Memorandum

DATE: January 24, 2014

RE: Capisic Pond Enhancement
Capisic Street
City of Portland, Doug Roncarati, Stormwater Program Coordinator, DPS, applicant
Project #: 2013-268 CBL 192-C001001

**G-001**

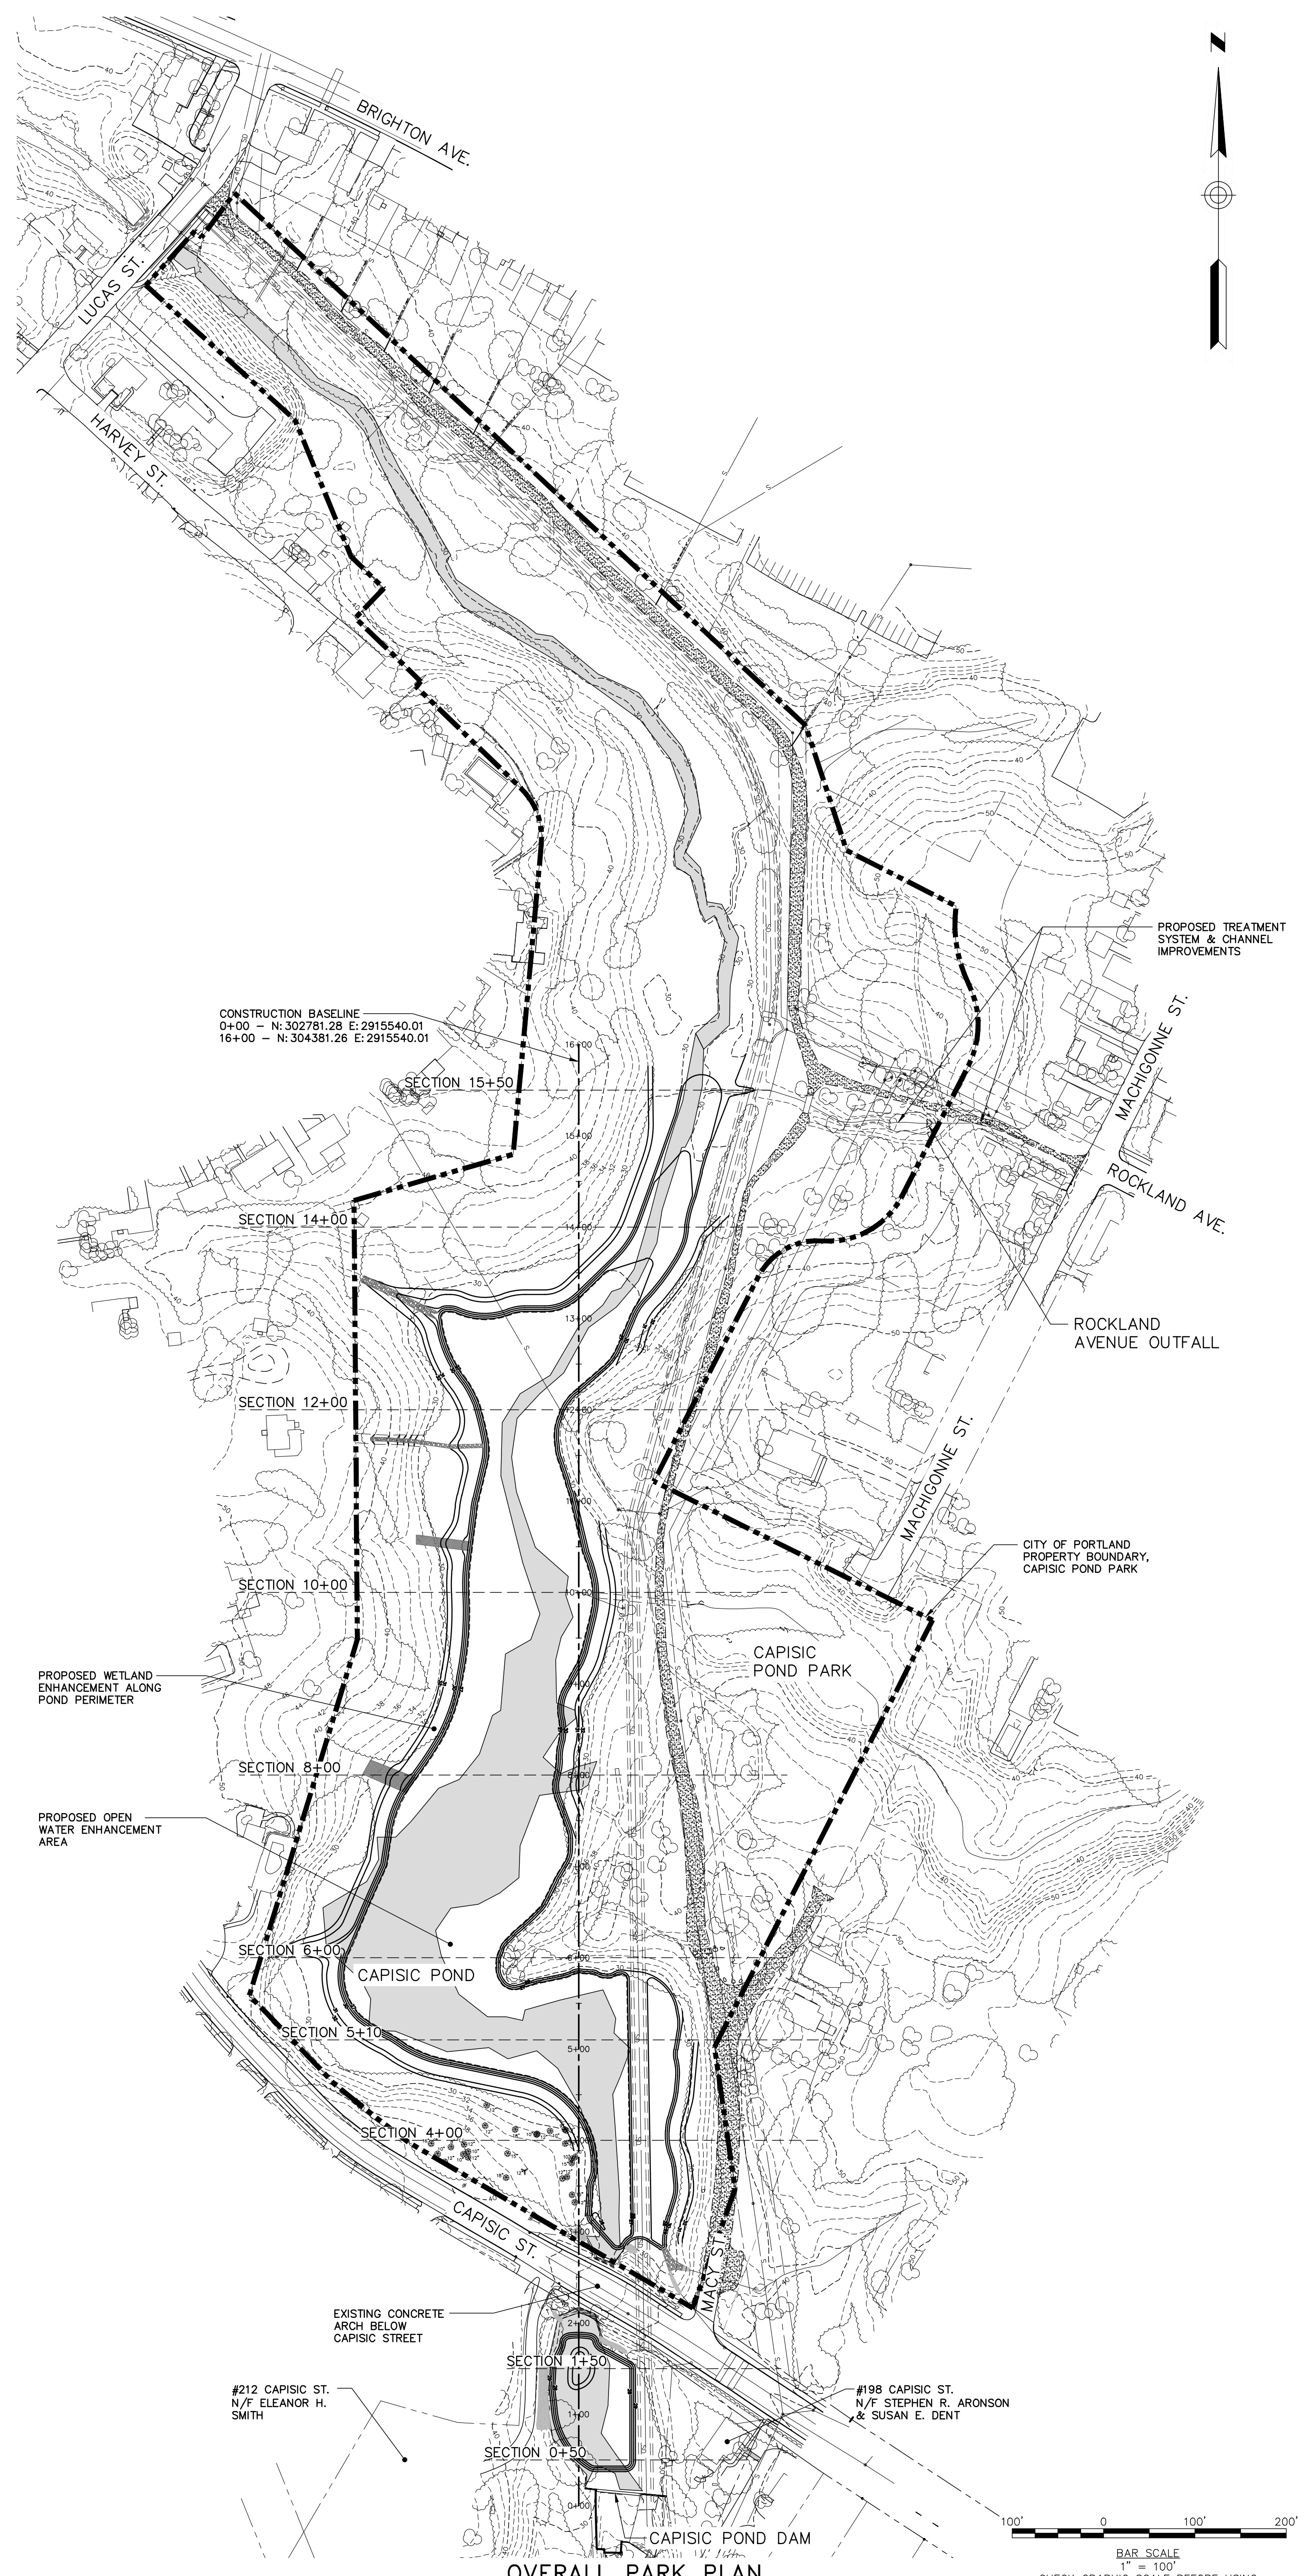
- *The applicant shall provide an estimate of both daily and peak hour truck volumes entering and exiting the site.*
- *Sight distance measurements shall be provided for proposed temporary driveways with discussion on meeting City standards.*
- *A proposed truck routing plan shall be documented. It is my understanding that it is likely that trucks will be destined to the City of Westbrook via Brighton Avenue. Accordingly, it seems reasonable that the routing consist of travel along Capisic Street to Brighton Avenue. I would suggest that truck activity avoid peak drop-off and pick-up times at Breakwater School. Also, provisions to ensure that vehicles are cleaned prior to entering the public street system should be included.*

The Contractor shall be responsible for any sweeping due to materials inadvertently falling on the roadway between the dredge and disposal site.
